Dublin Cycling Campaign

26th March 2024

## MetroLink Oral Hearing

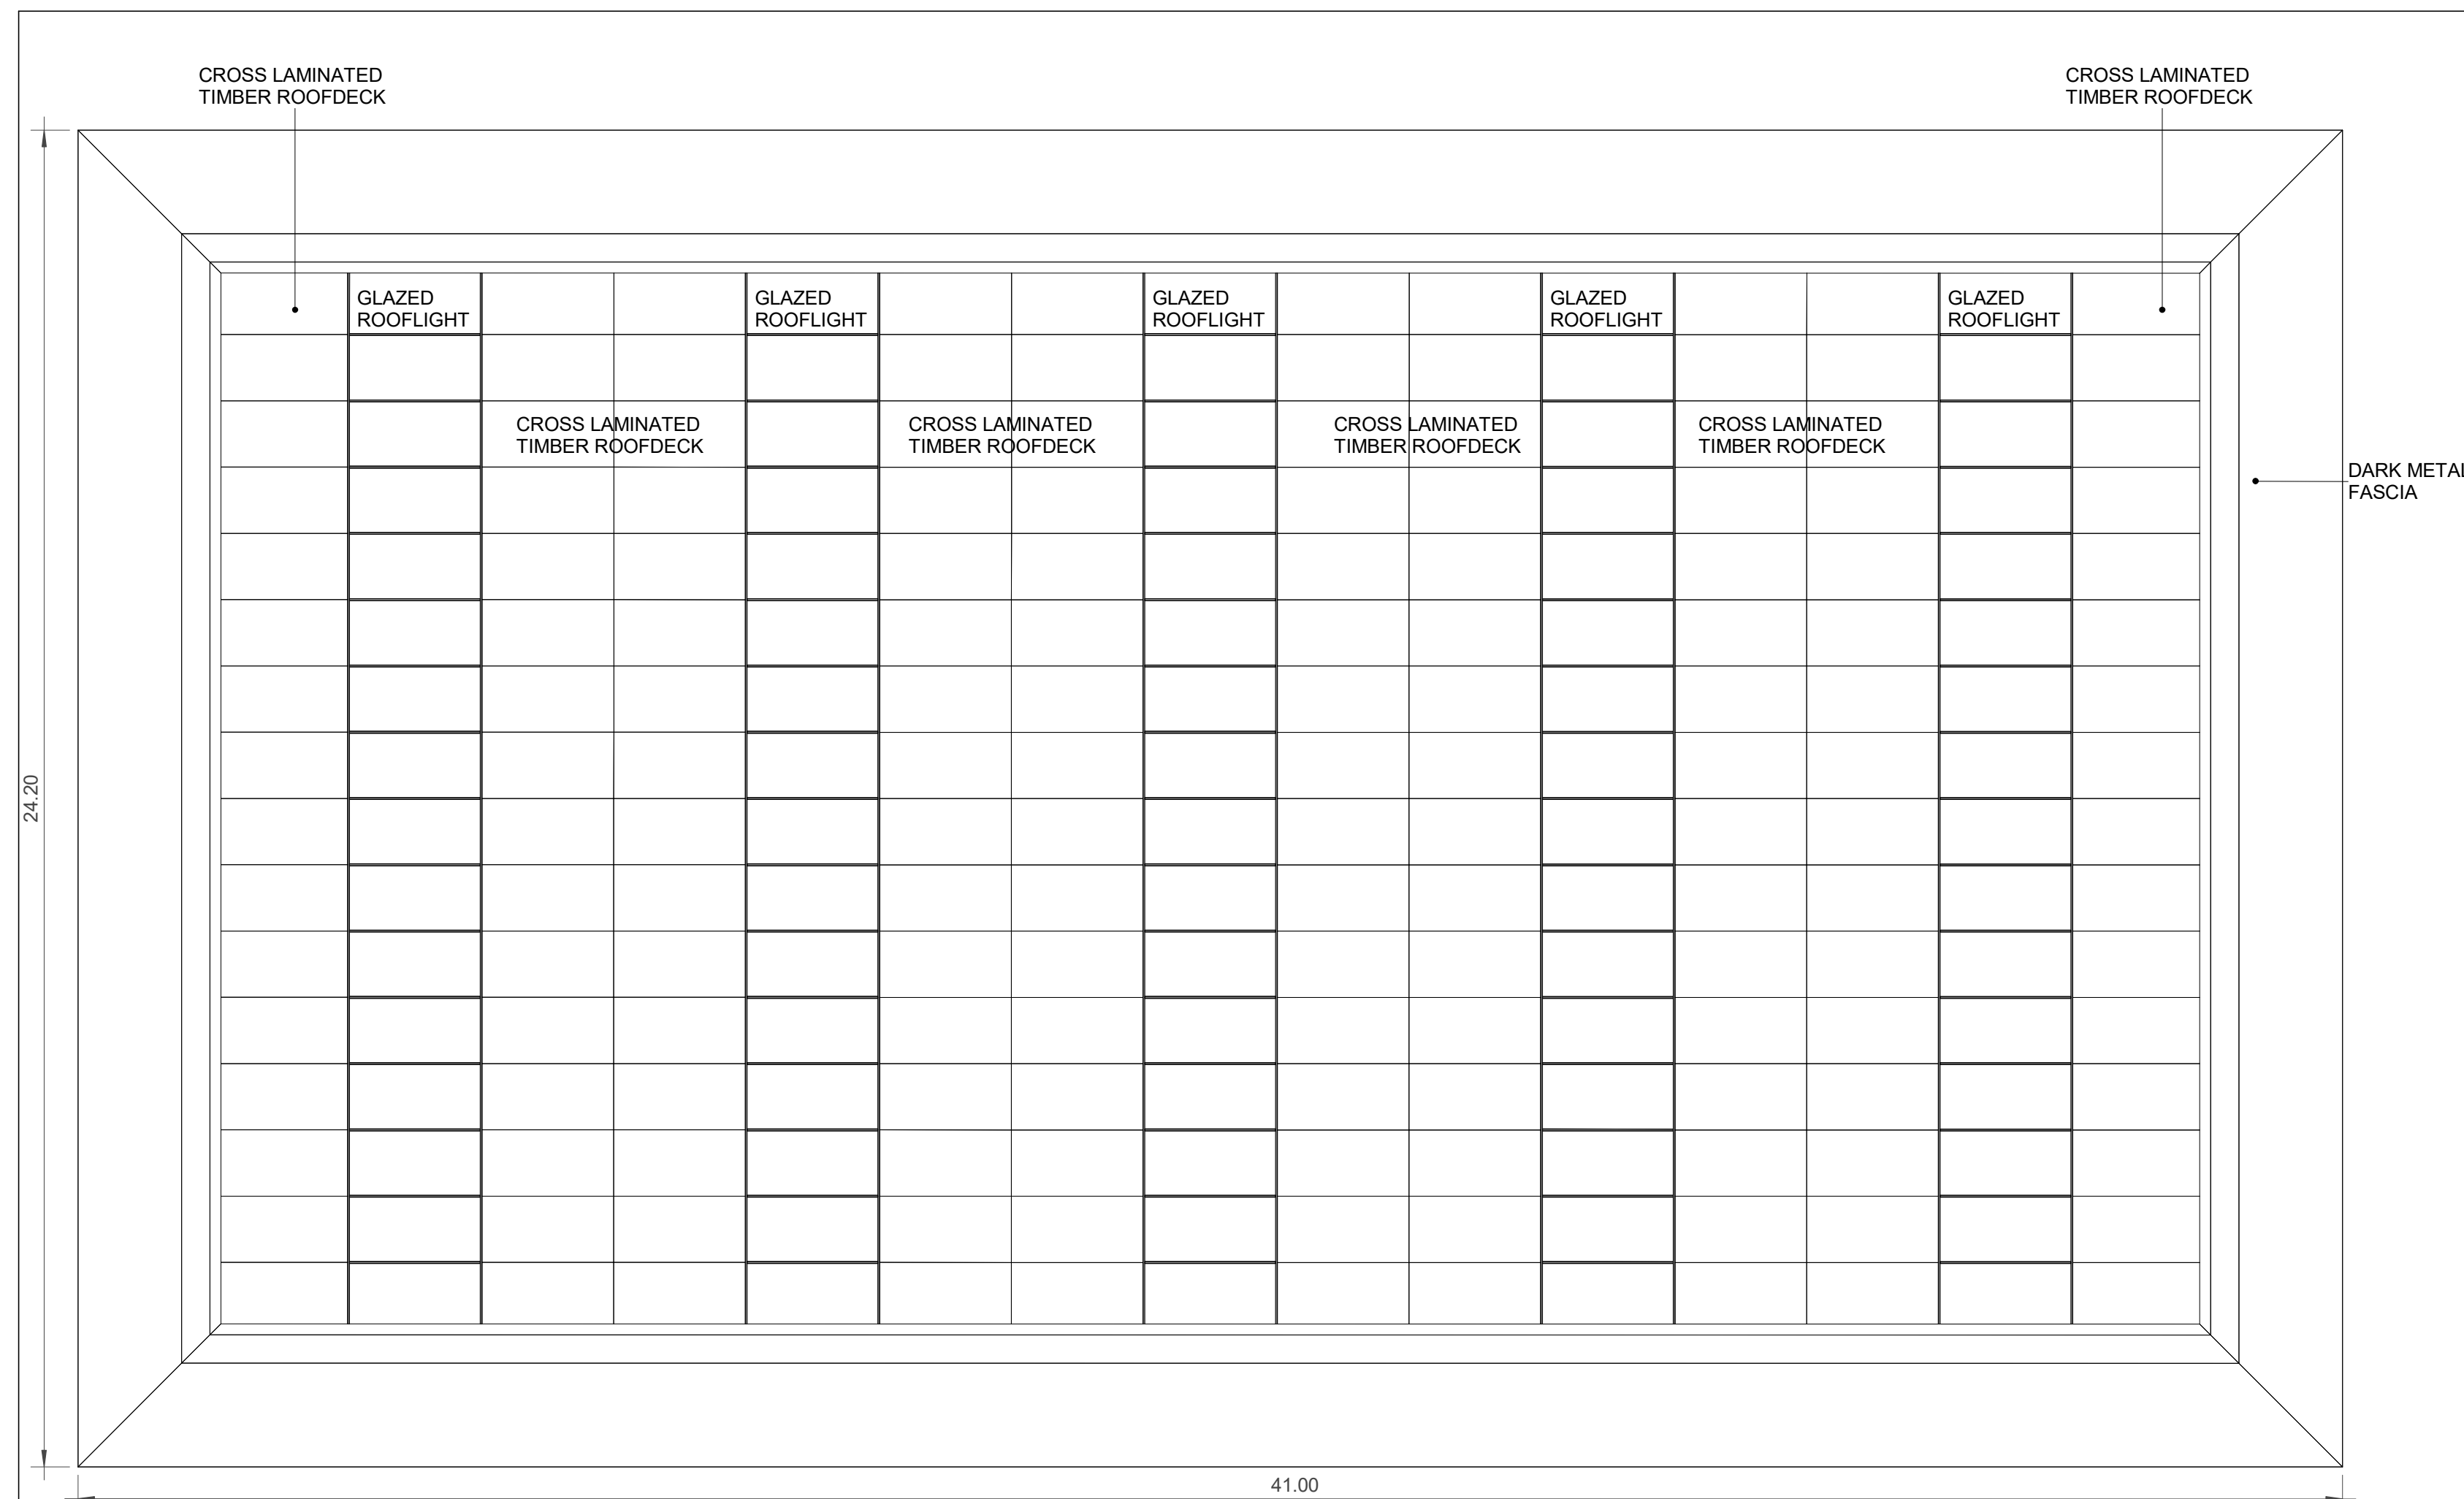
1. On day one, Fingal County Council mentioned that TII had agreed to provide more than the planned 250 cycle parking spots at Estuary station to support future development in this area. Can TII publish the information related to these changes to their website please?
2. Do any of the cycle parking spots provide for accessible cycles, cargo bikes, tricycles etc?
3. Why has TII not leveraged two-tier cycle parking at indoor cycle parking areas or at the back of Glasnevin interchange station (43% provision) cycle parking?
4. Why was an additional underground cycle parking area included in the plan for the Griffith Park station but not for other stations?

There is no city centre station with more than 50% provision. The Mater (47% provision, none covered) and Stephen's Green (15% provision, none covered) stations are near sensitive receptors. The O'Connell Street station (0% provision) is beneath a private development. Similarly, Charlemont (30% provision, none covered) has no available underground space as it abuts private development. Tara Street (13% provision) is the only likely city centre location that could provide for a city centre integrated cycle parking location to compensate for the lack of cycle parking at all other city centre stations. It is a key interchange station and on both the primary and secondary GDA Cycle Network, with easy access to the Liffey Cycle Route.

Drawing Title	METROLINK - STRUCTURES M50 VIADUCT PLAN LAYOUT AND LONGITUDINAL SECTION	Drawing Status	S0
Drawing N°	ML1-JAI-SRD-ROUT_XX-DR-Y-04001	Plan Drawing N°	ML-VR 303 G-J
Scales Original Size A1	1:200-1:100	1:200 0 1 2 4 6 8 10 1:100 0 0.5 1 2 3 4 5	Sheet 1 of 1

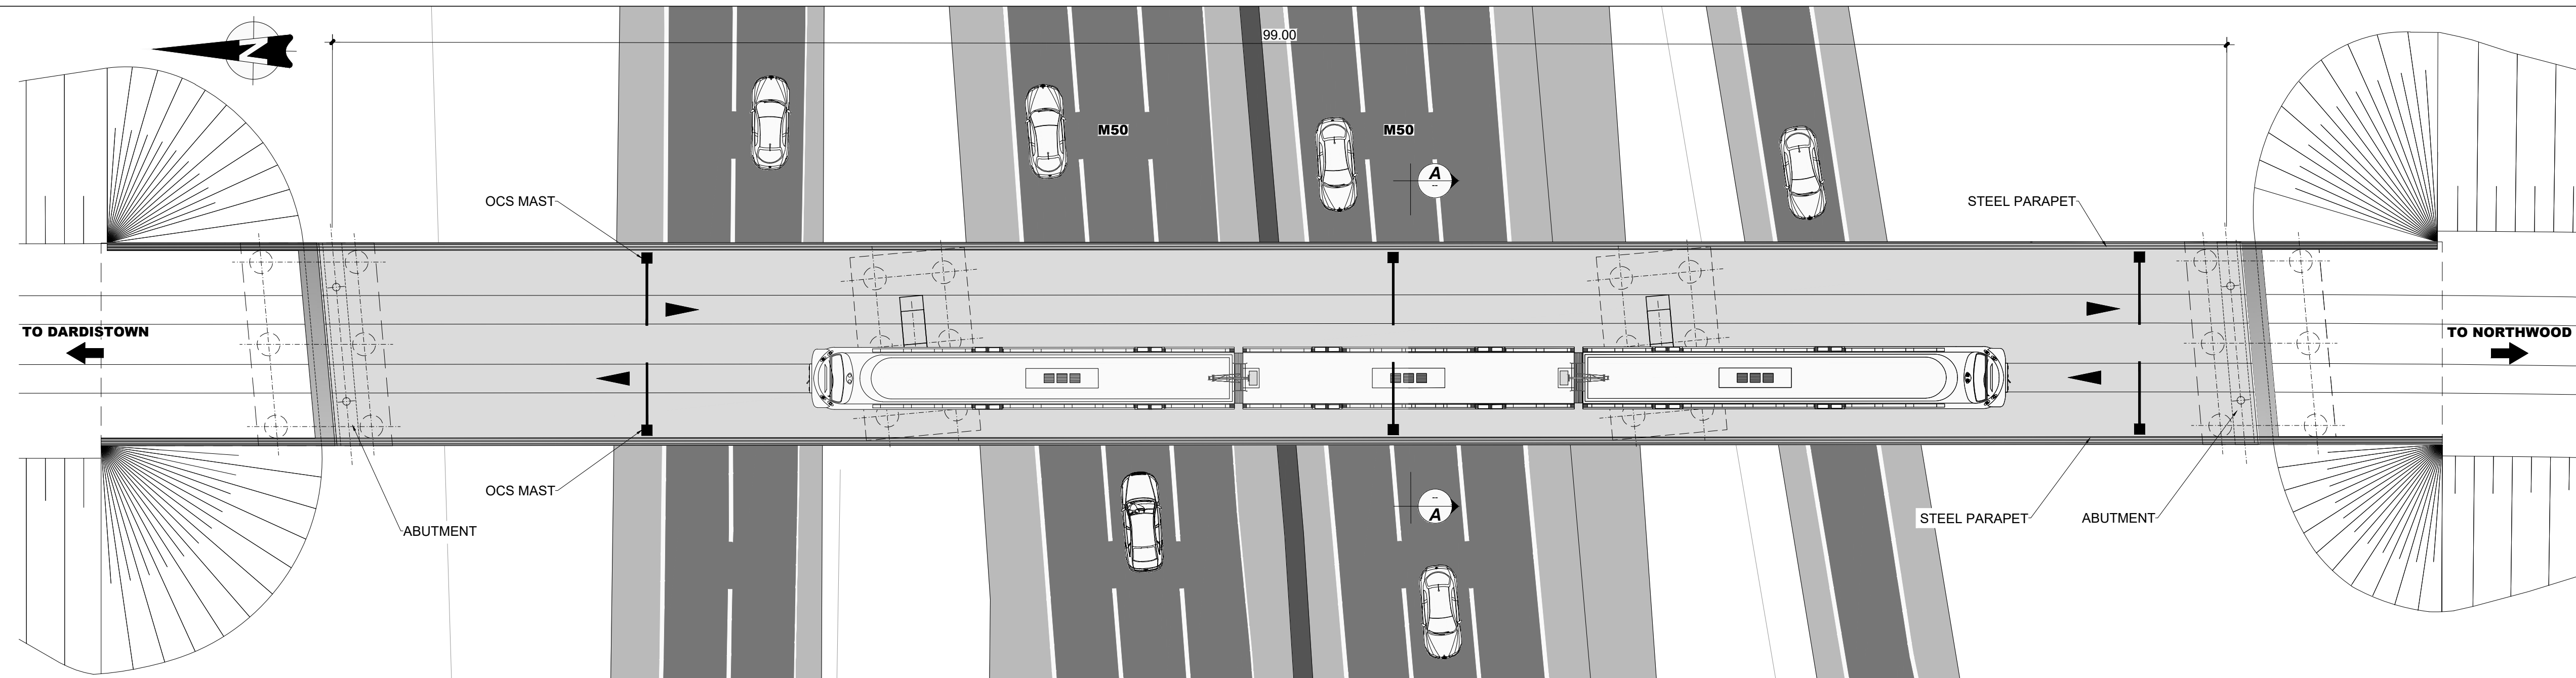
### 3 Pedestrian and Cycle Bridge over M50

In our original public consultation response we raised the issue of Fingal County Council Development Plan Objective MT15;

*"Investigate and avail of the opportunities provided by new Metro North and any other public transport infrastructure to provide new cycle and pedestrian links including crossings of the M50 which currently represents a major barrier to active transport modes"*

A recent AIE request (AIE/138/24) to TII returned a document from October 2019 (attached as appendix) showing shared agreement by TII and NTA that:

*"Recommendation: Provide a separate 2 way cycleway and 2 way footpath bridge to the west of the existing [MetroLink] bridge, of an overall width of at least 6m."*

*"Locating this bridge on the west side of the existing bridge will impact less stakeholders, allow the foundations for the Old Metro North M50 Bridge to be utilised, and allow for efficient construction and design."*

Section 7.3.3 of EIAR Chapter 7, Consideration of Alternatives states:

*"An analysis was also undertaken to identify if a pedestrian and cycle lane could be added to the M50 Viaduct. However, it was determined not to be feasible because, there would need to be significant separation from the running train alignment for safety reasons and this would result in a much more significant bridge structure spanning the M50 than that required for the proposed Project."*

1. If the bridge was both feasible and recommended, why was this proposal for integrating active travel into the project dropped from the planning application?
2. Does the lack of an active travel bridge over the M50 at this location impact on the future sustainable development of the Daristown lands zoned for 'High Technology' or 'General Employment'?
